Online Comment

Application H09-0980-21
Location Land North of Tudor Lodge Fen Road Holbeach PE12 8QD
Proposal Residential development comprising 5 detached dwellings off a private drive

Date Submitted 07-10-21
For/Against Comments

RESIDENTIAL DEVELOPMENT, TUDOR LODGE,
FEN ROAD, HOLBEACH

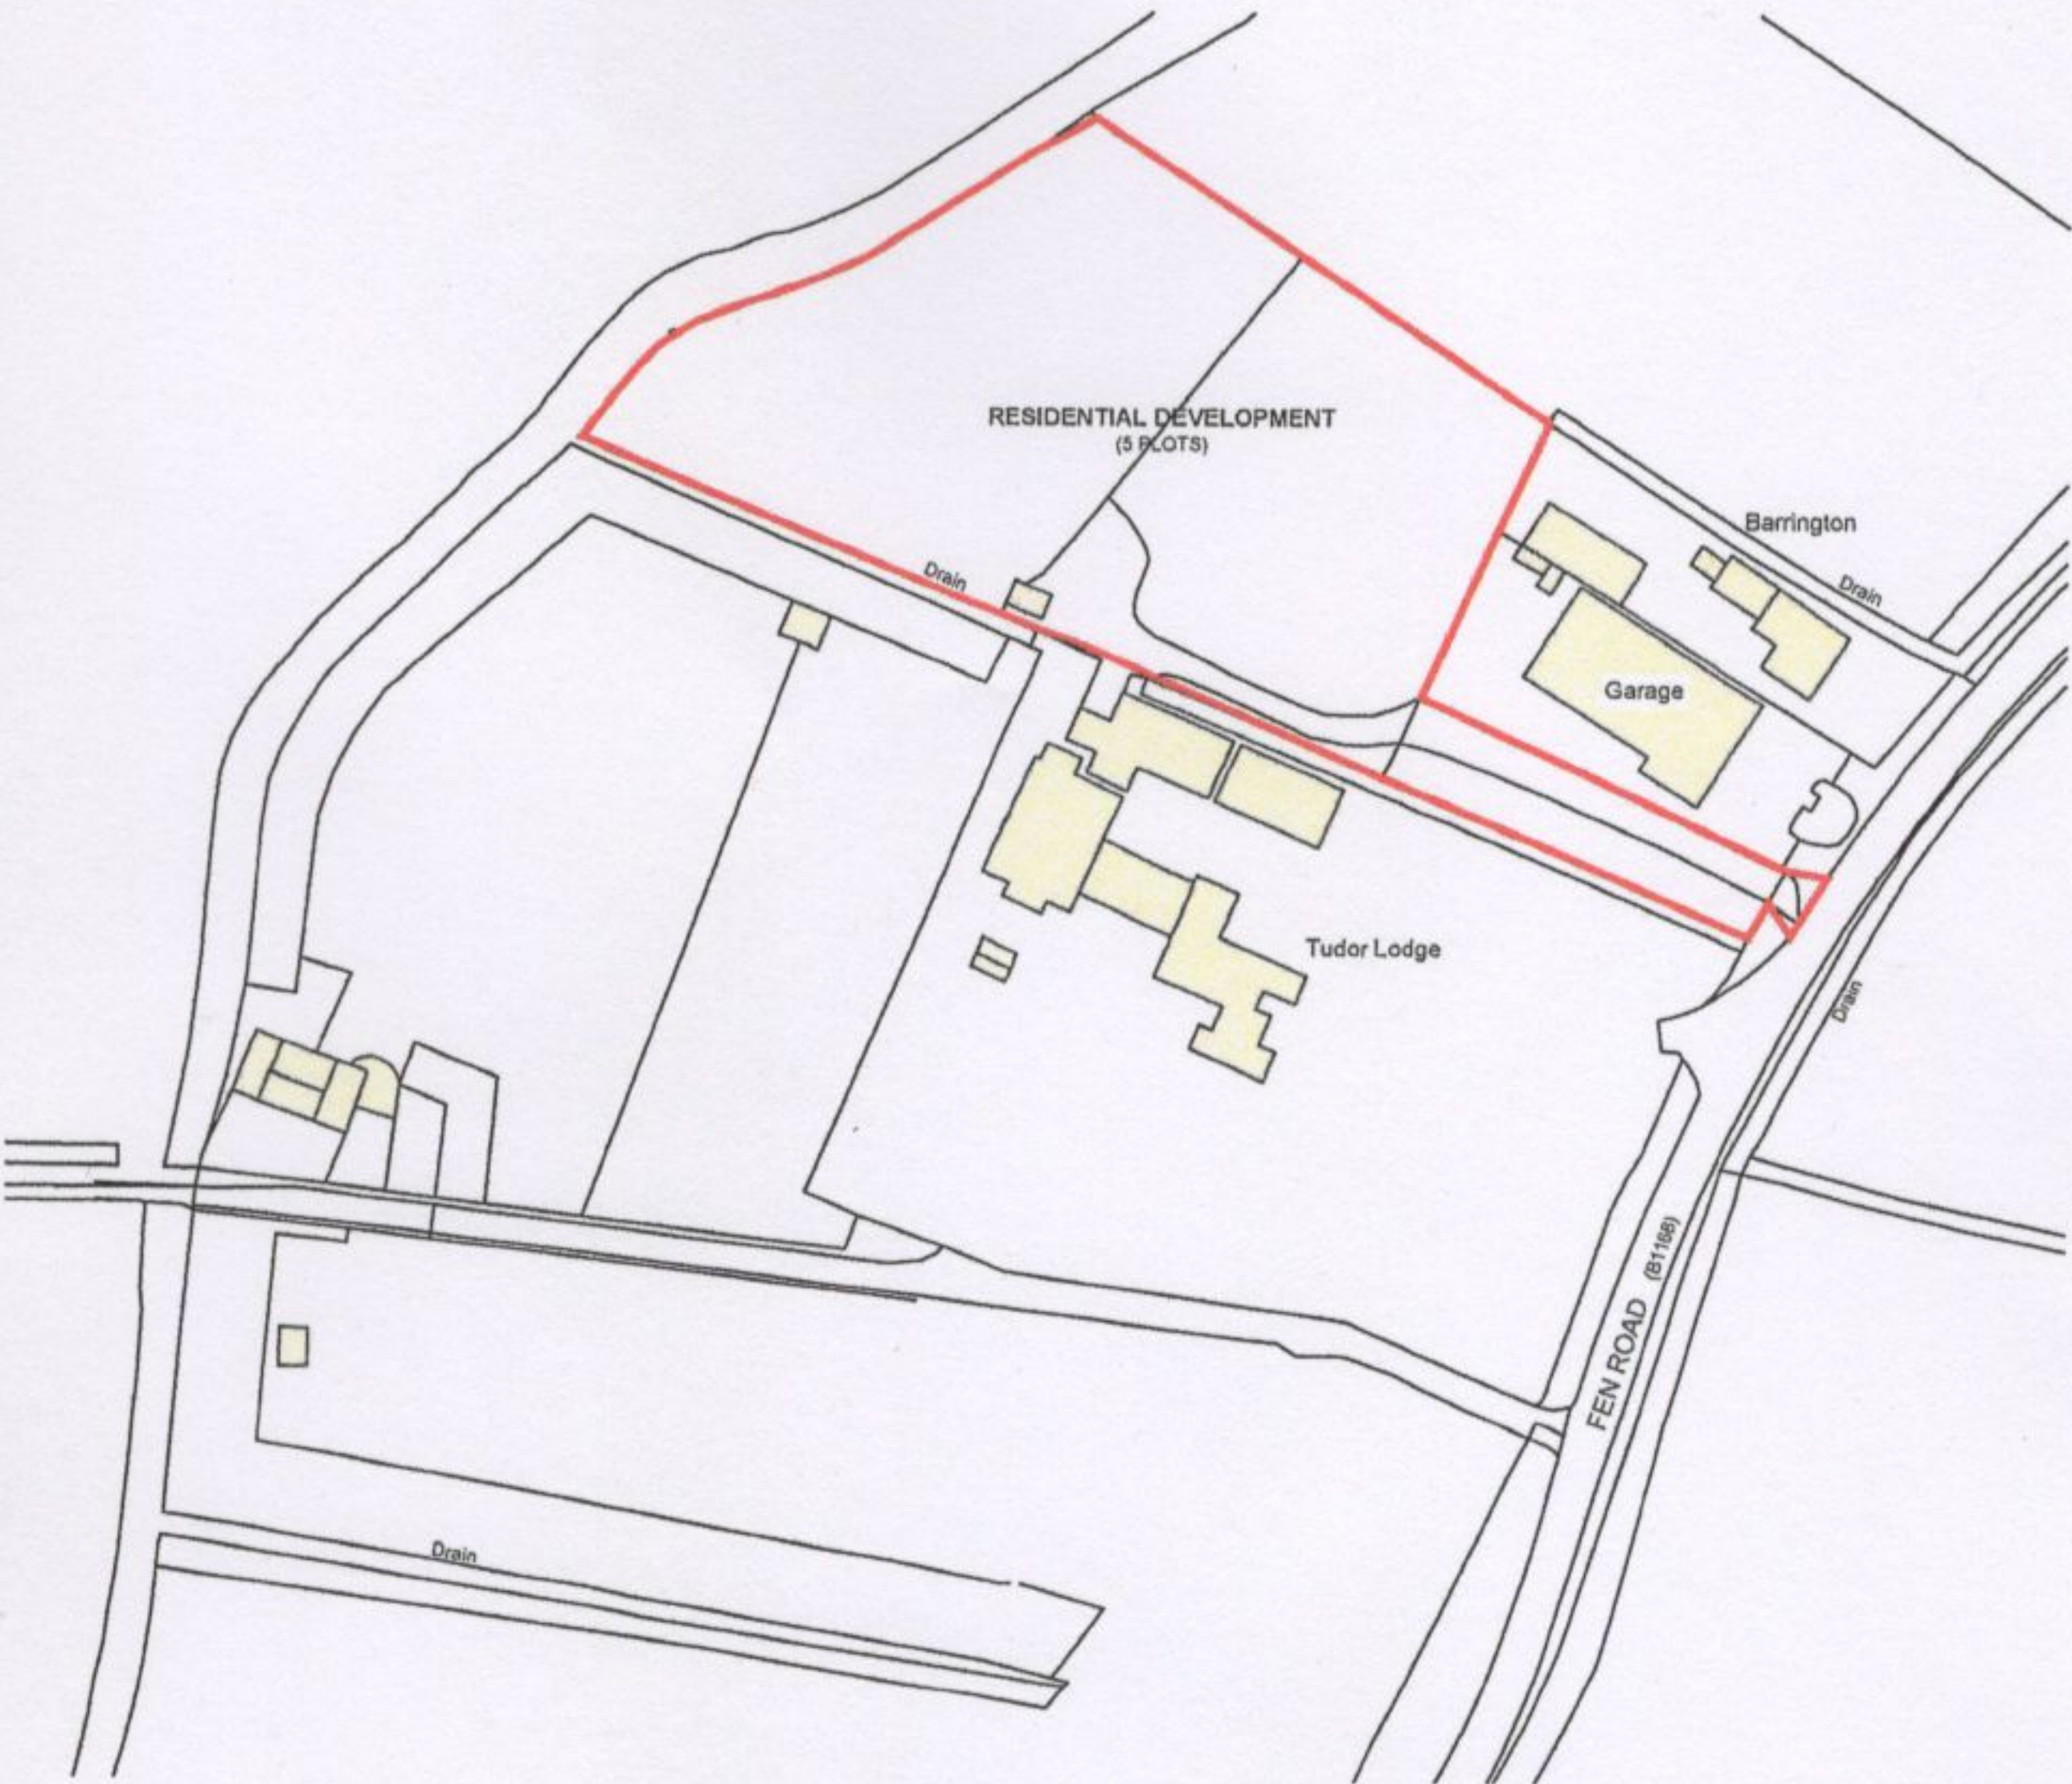
Need clarification on waste collection and private drive is suitable for 18T fire appliance.
